From: Andrew Wood
Sent: 25 April 2018 16:27
To: Planning.Responses
Subject: FW: BE/37/18/CLP - hardstanding 24 Winston Close North Bersted Bognor Regis

BE/37/18/CLP – hardstanding

Block Plan

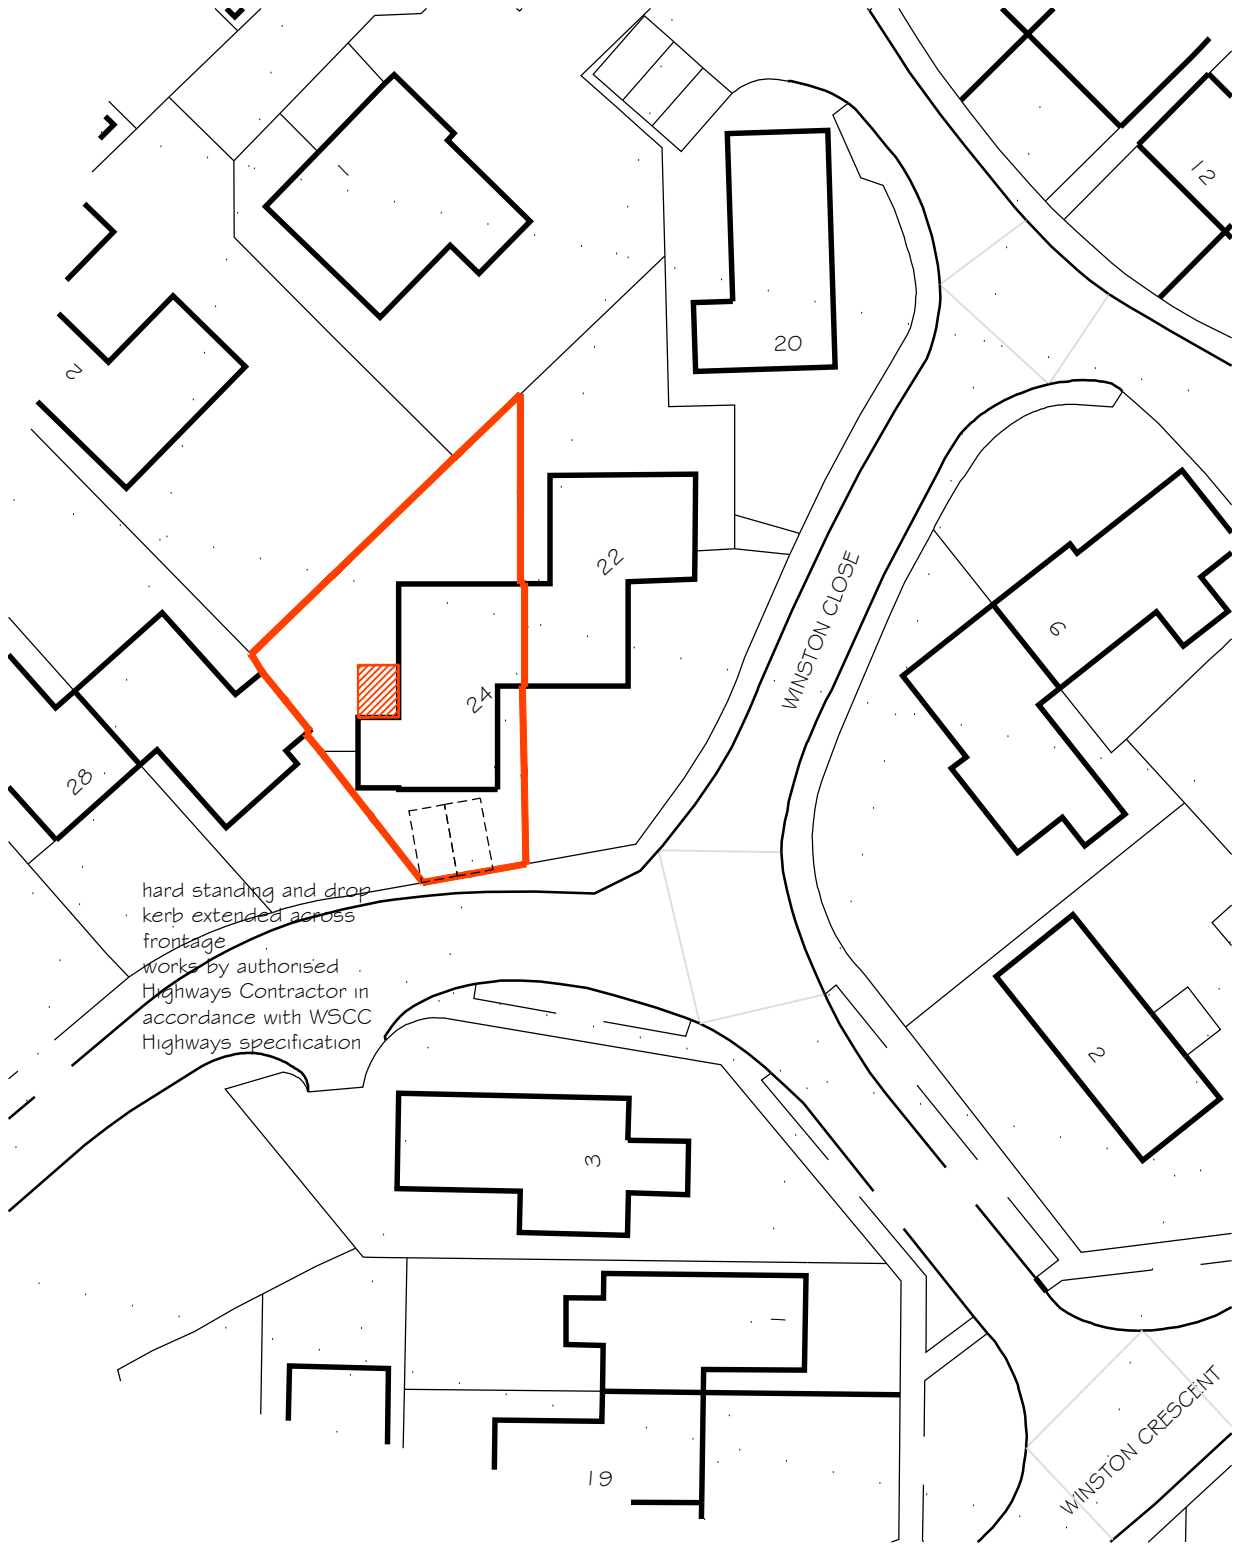
Can you please confirm that the hardstanding to be constructed complies with the following regulation ;

F.2 Development is permitted by Class F subject to the condition that where—

- (a) the hard surface would be situated on land between a wall forming the principal elevation of the dwellinghouse and a highway, and
- (b) the area of ground covered by the hard surface, or the area of hard surface replaced, would exceed 5 square metres,

either the hard surface is made of porous materials, or provision is made to direct run-off water from the hard surface to a permeable or porous area or surface within the curtilage of the dwellinghouse.

i.e. please confirm that 'the hard surface is made of porous materials, or provision is made to direct run-off water from the hard surface to a permeable or porous area or surface within the curtilage of the dwellinghouse.

Further to your request we can confirm the hardstanding will be constructed with porous materials or provision made to direct water run off from the hard surface to a permeable or porous area within the curtilage of the dwelling house.
